Your Ref: OWPC14139
Our Ref: R/88/17/OUT 20-04-2017
Please ask for:
Mr D Easton

Outline application with all matters reserved for 1 No. dwelling & detached garage
40 Bushby Avenue Rustington

Thank you for your internet representation made on 3rd June 2017 which has been recorded as '**an objection**' with the comments as follows:

General Arrangement Plan ~ As Proposed

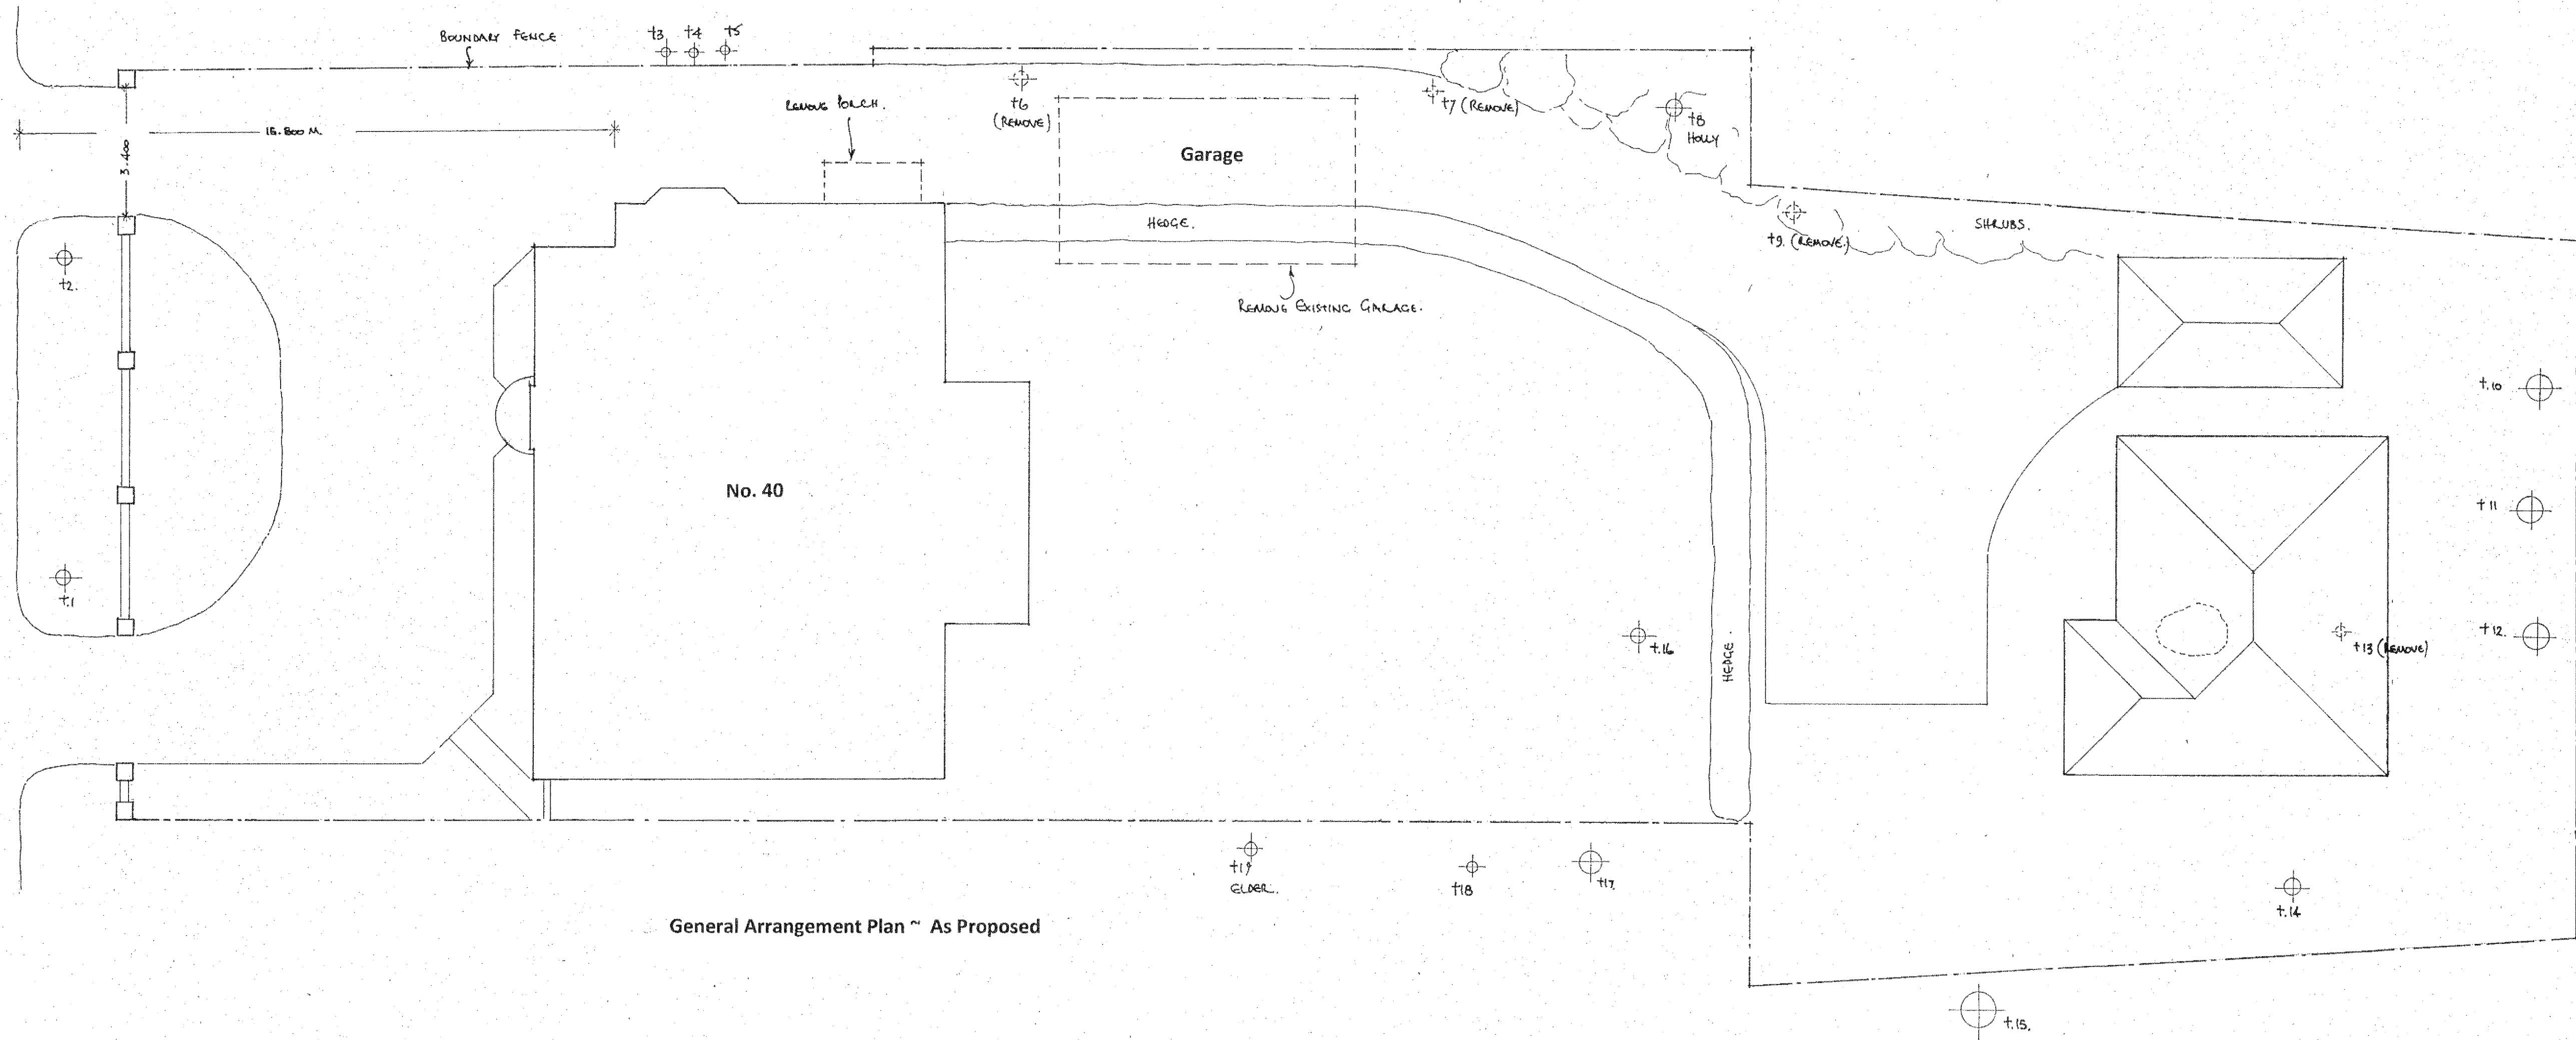
- 1. The proposed Development would create an access road at the rear of existing properties, and so compromise the security of these properties. This would in turn increase insurance costs and devalue the properties.*
- 2. There is no surface drainage on the Sea Estate, only "soakaways". If less land is available through this development, there would be an increased risk of flooding.*
- 3. The extra noise and air pollution would affect neighbouring properties, including the Zachary Merton hospital.*
- 4. The wildlife including Bats, Owls and Newts in the surrounding area would be affected.*
- 5. Everyone has the right to privacy and to enjoy the peace and quiet of their home; this proposed Development would impact on these rights.*
